18 July 2016

File No: 2016/355150
Our Ref: R/2016/11/A

RE: SSD 6633, Darling Square - Mixed Use Residential Building within the South East Plot (SSD 6633)

Figure 8: Pedestrian wind speed measurement locations with comfort/distress ratings – Ground Level

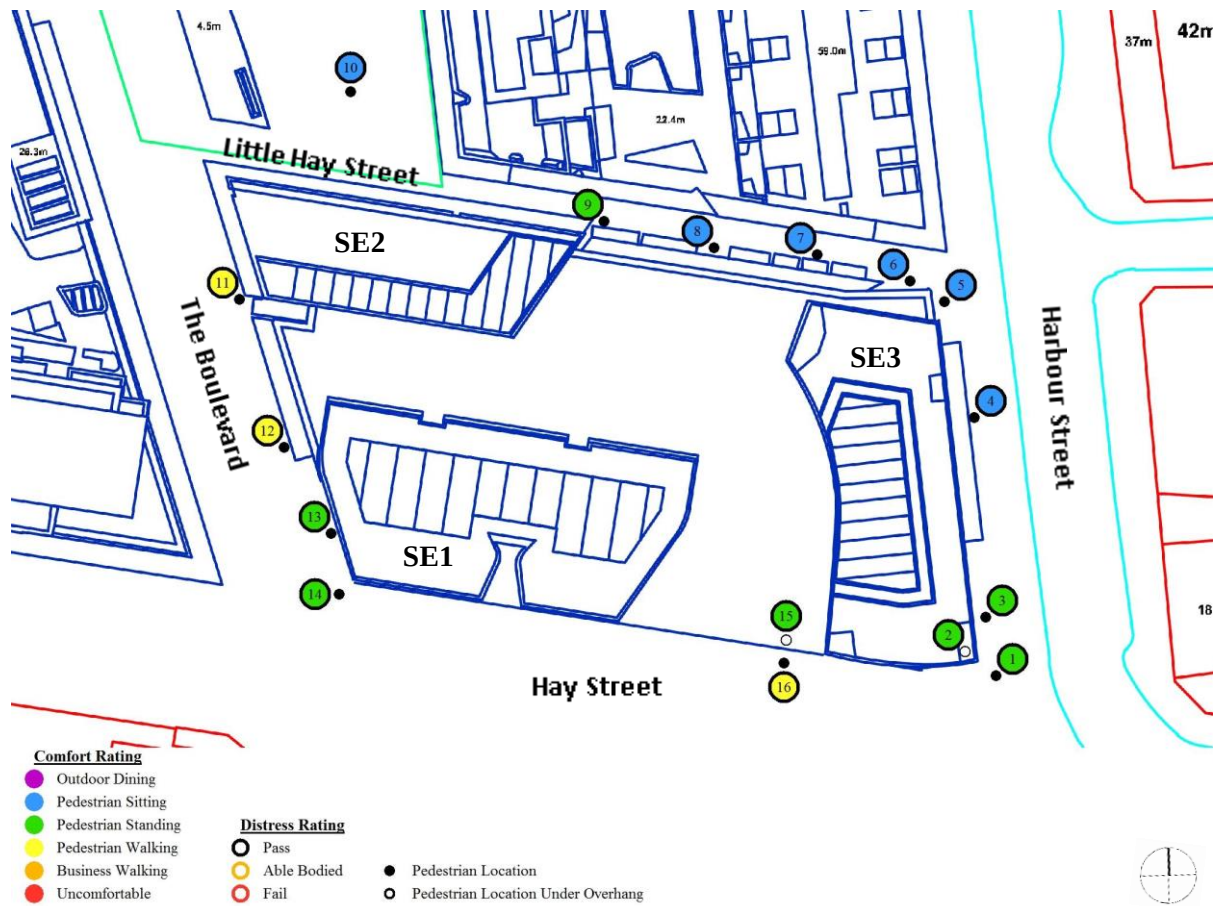
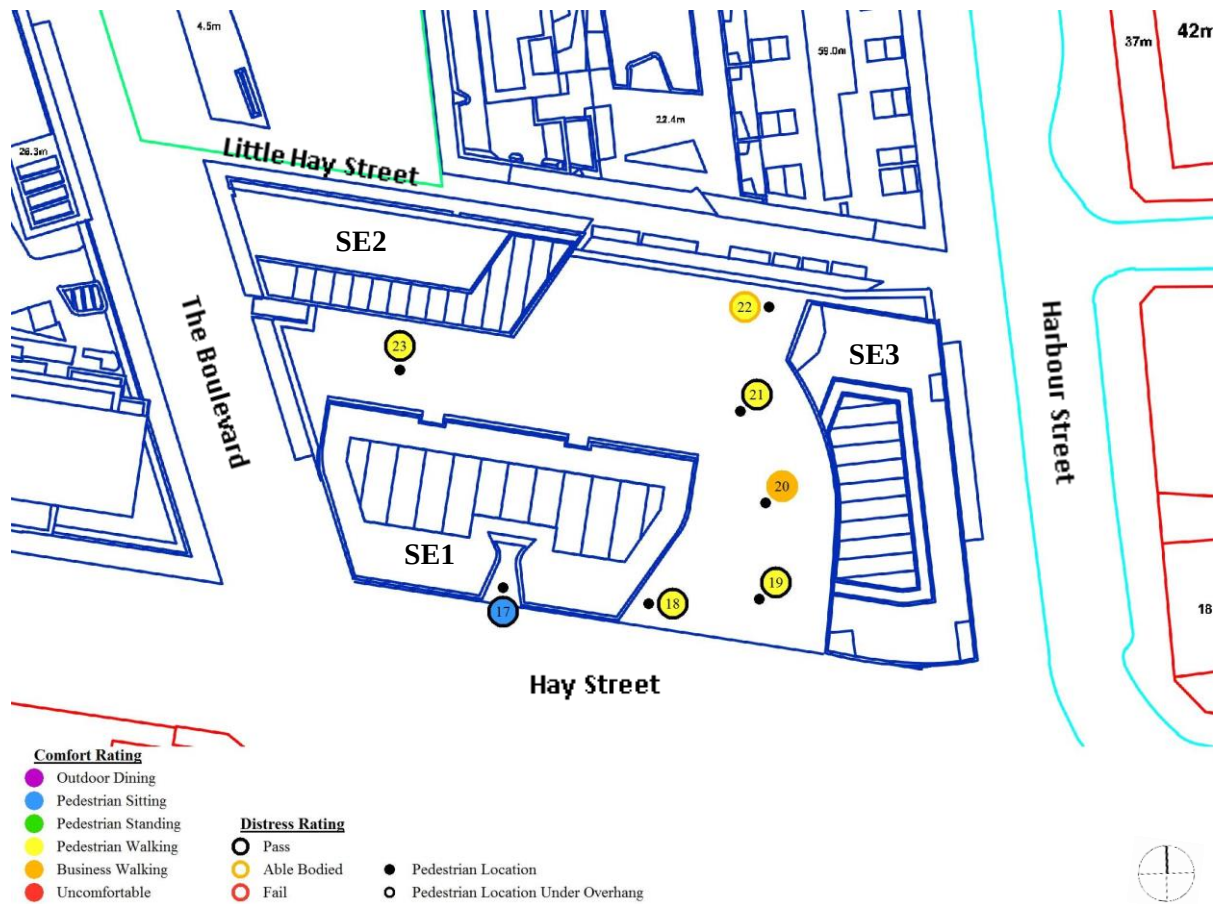
Wind Effects			
The City requests that the Applicant confirm whether the	As discussed above, this matter has been addressed in the covering	Partially	The amended plans incorporate wind protection measures on the podium. The City remains

Issue	Applicant's Response	Issue Addressed?	City's Contention
findings and recommendations of the wind assessments for the North Plot and South-East Plot are capable of being incorporated. For example, significant wind effects are predicted at the ground level and podium levels of the South-East Plot, negative effects not compatible with outdoor dining are predicted along Little Hay Street. The City has consistently raised the need for the tower forms of the Darling Square development to be setback from the podium edge at least 5m to mitigate downdrafts. This is a standing recommendation. The Stage 2 DA should incorporate all necessary wind mitigation measures at this stage.	Response to Submissions Report and is outlined in the updated wind assessment (refer to Appendix J).		concerned that wind conditions in the public domain at ground level have been compromised due to the strategy of building to the perimeter edge.

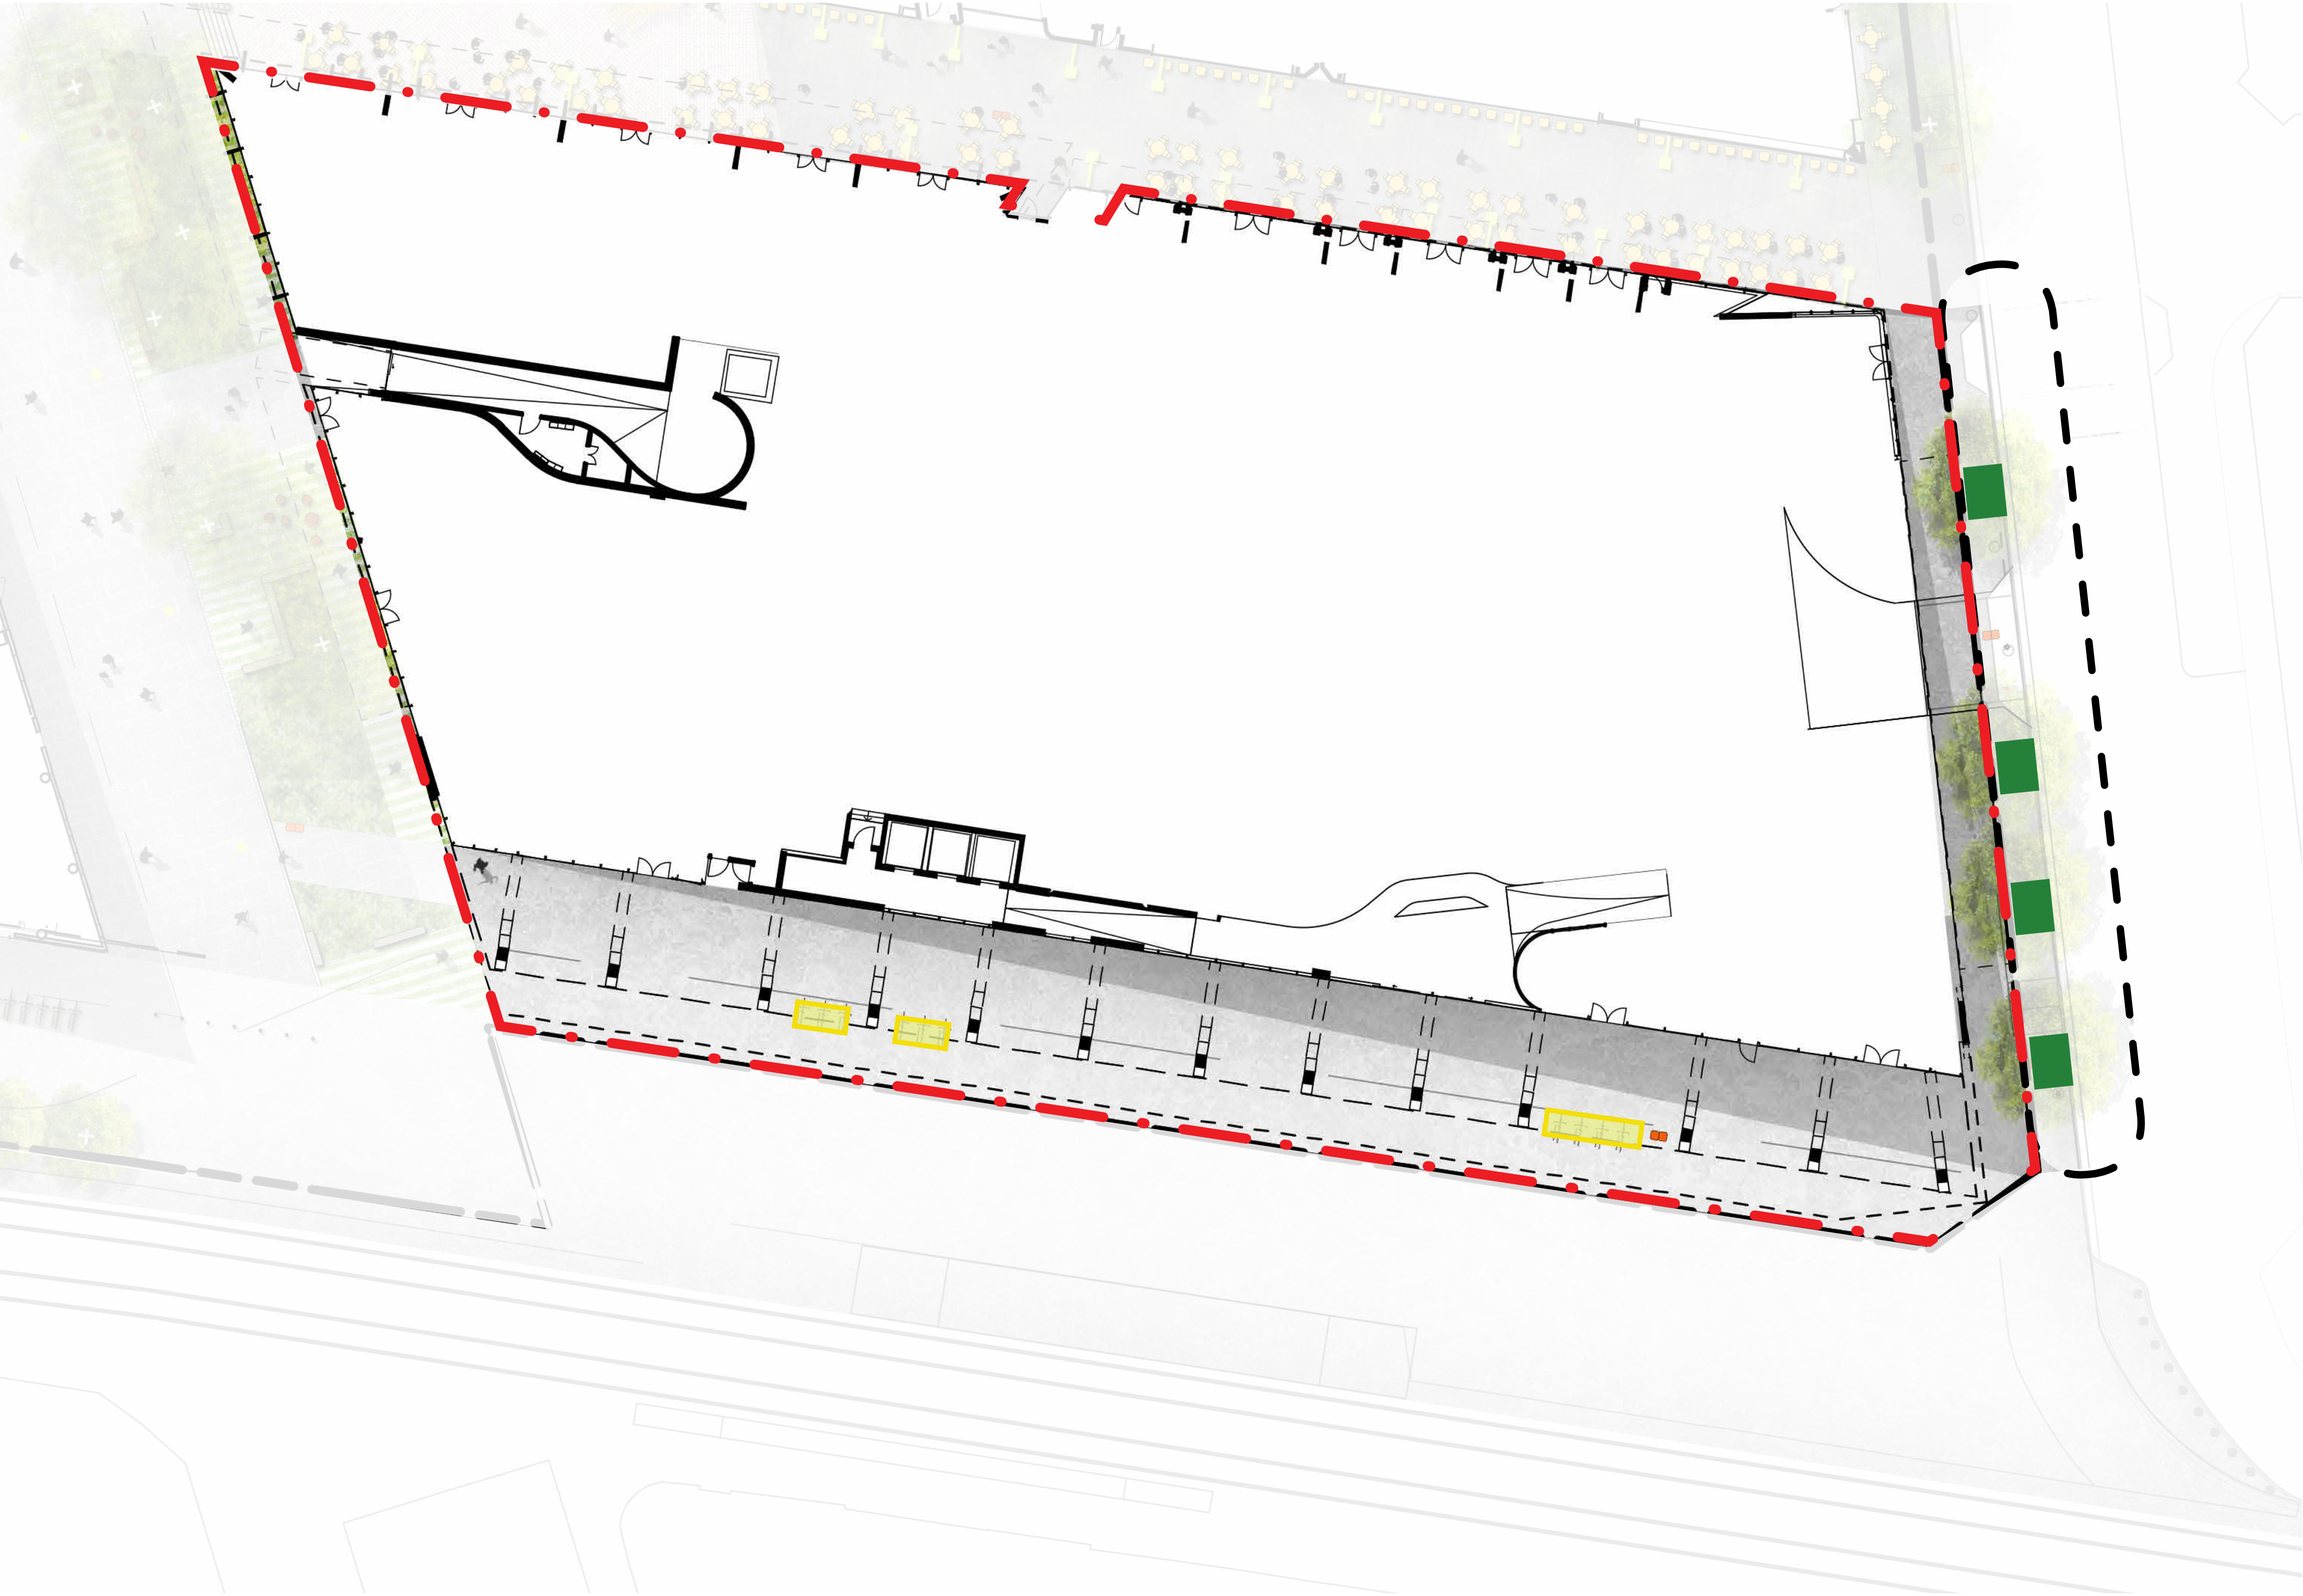
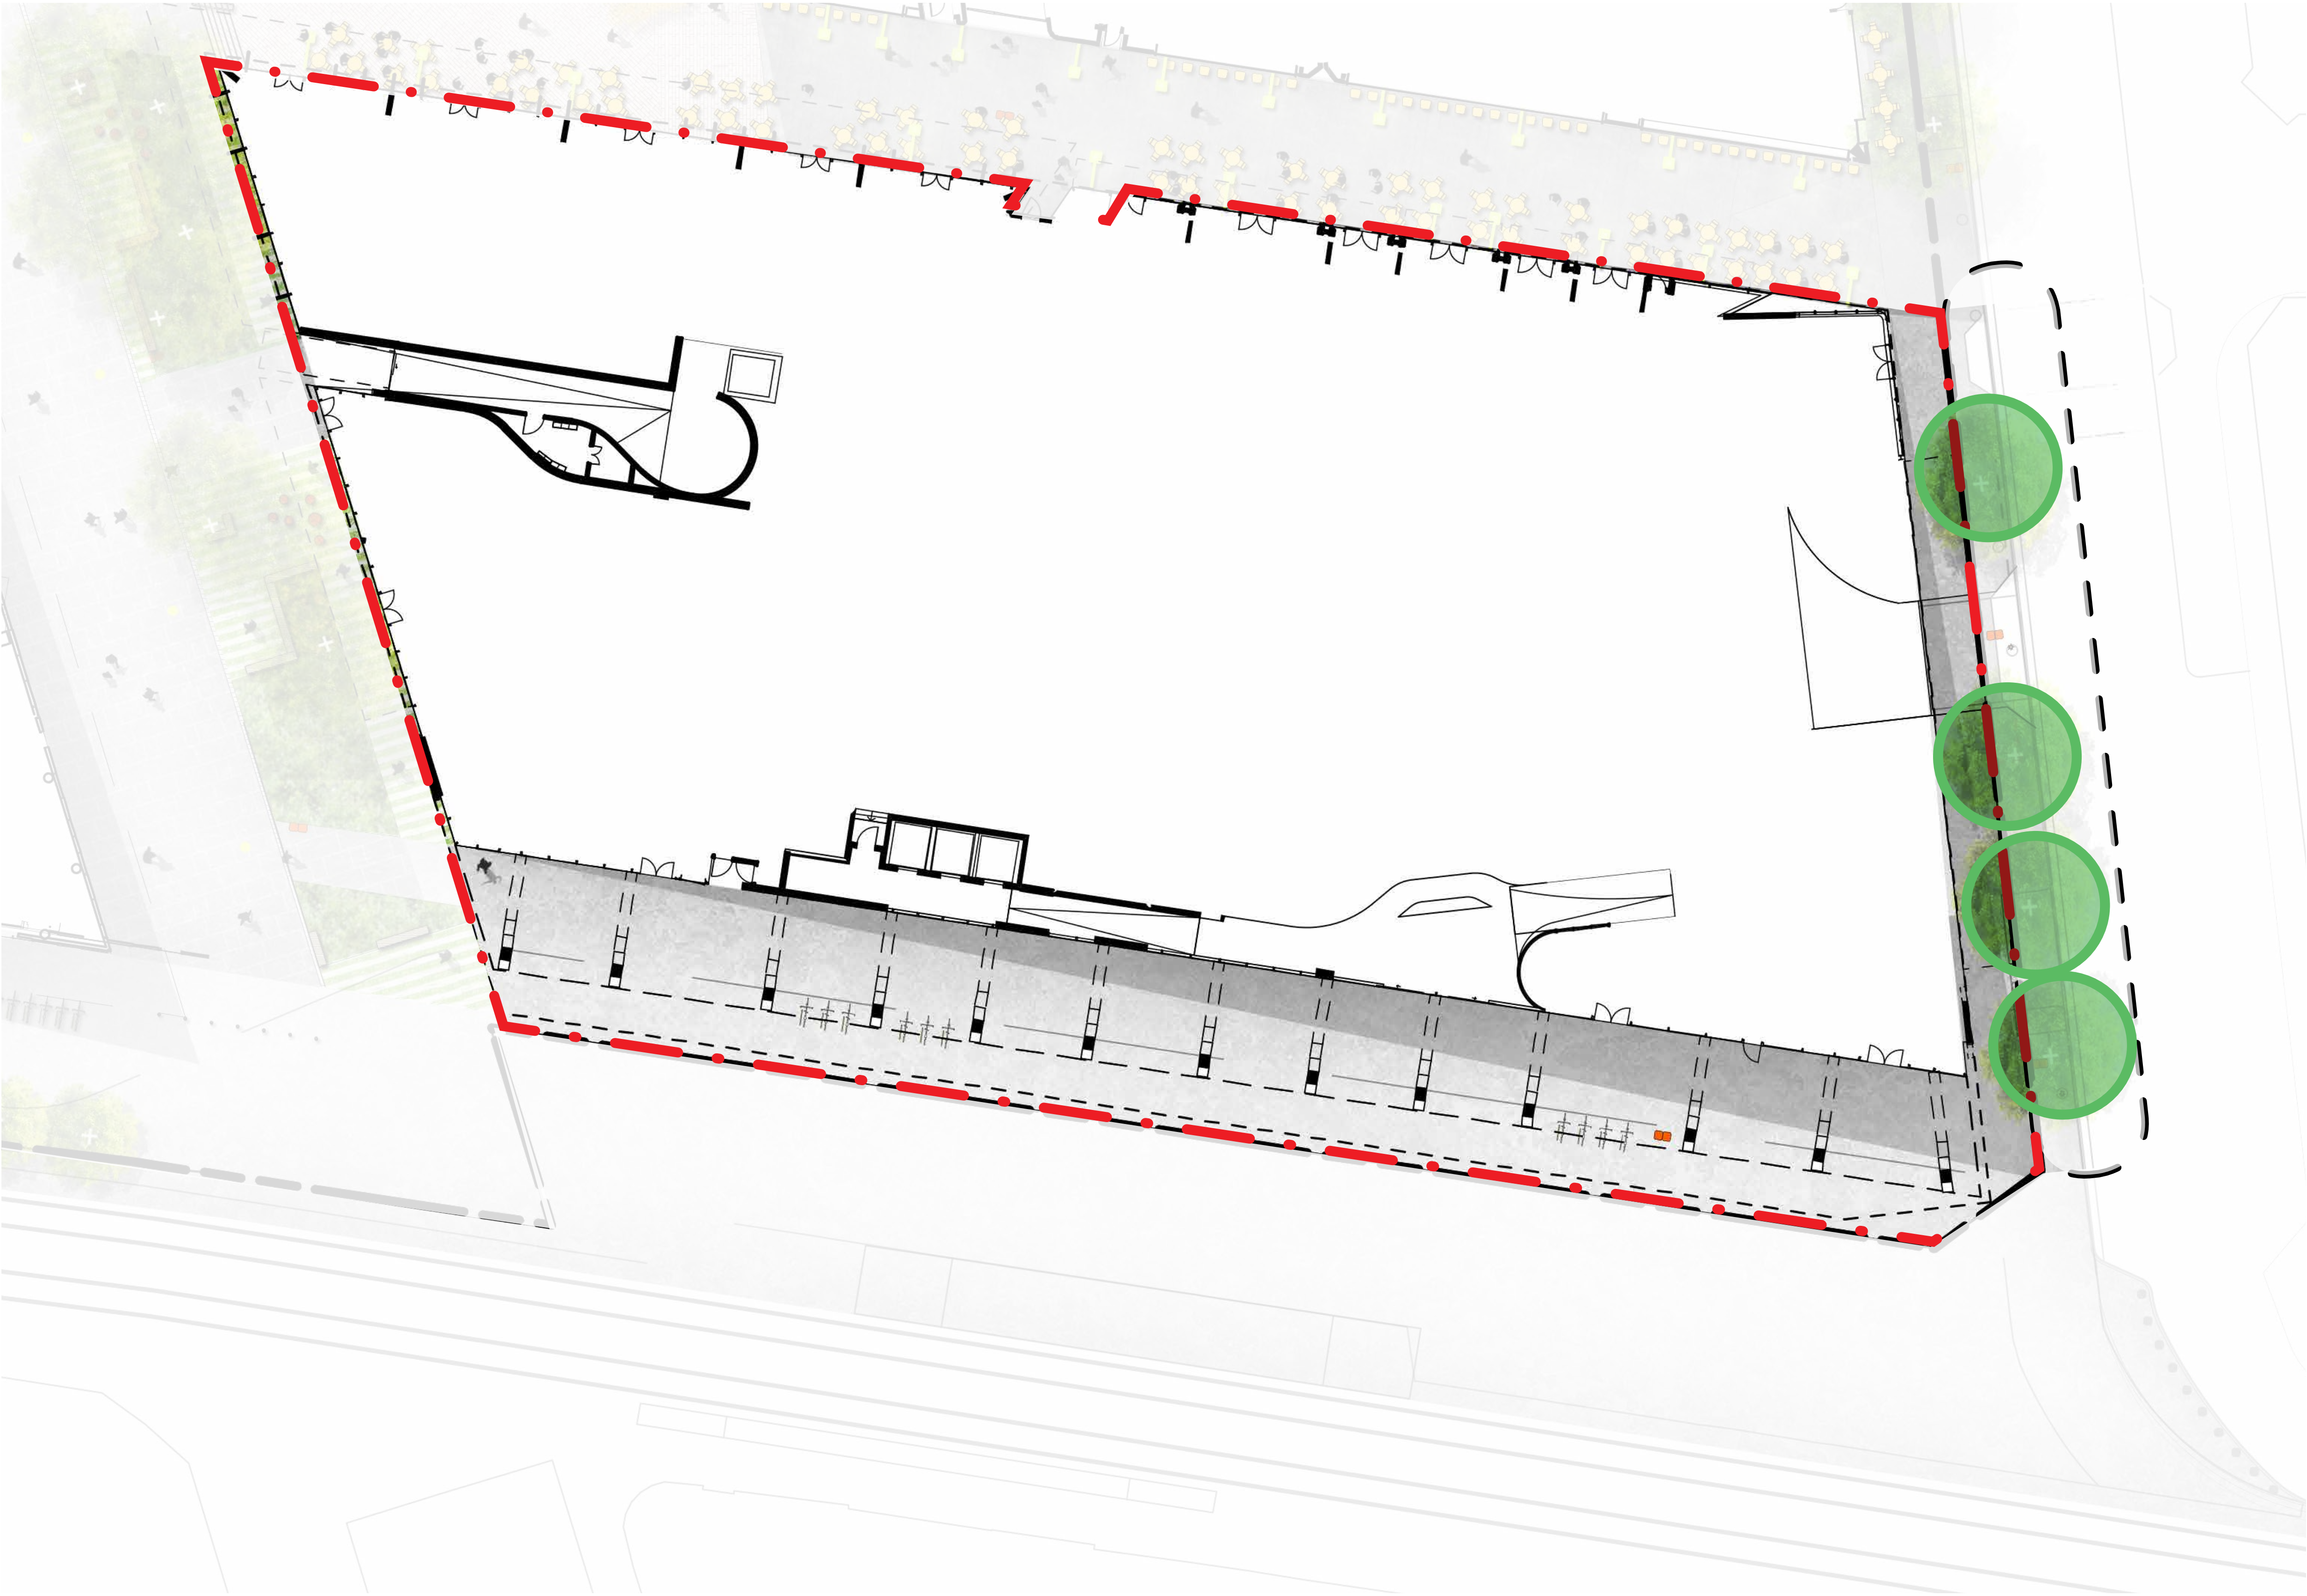
The *South East Plot and Public Domain Planting Plan* (drawing. no 14076-SSDA9-04) prepared by Aspect Studios dated July 2015 proposes new street tree planting.

The City request that tree planting is not undertaken by the developer. The City's tree management team is responsible for managing and maintaining all trees within the Public Domain. Due to the reoccurrence of inheriting poor quality trees from developers, it is preferable that Council undertakes any new plantings.
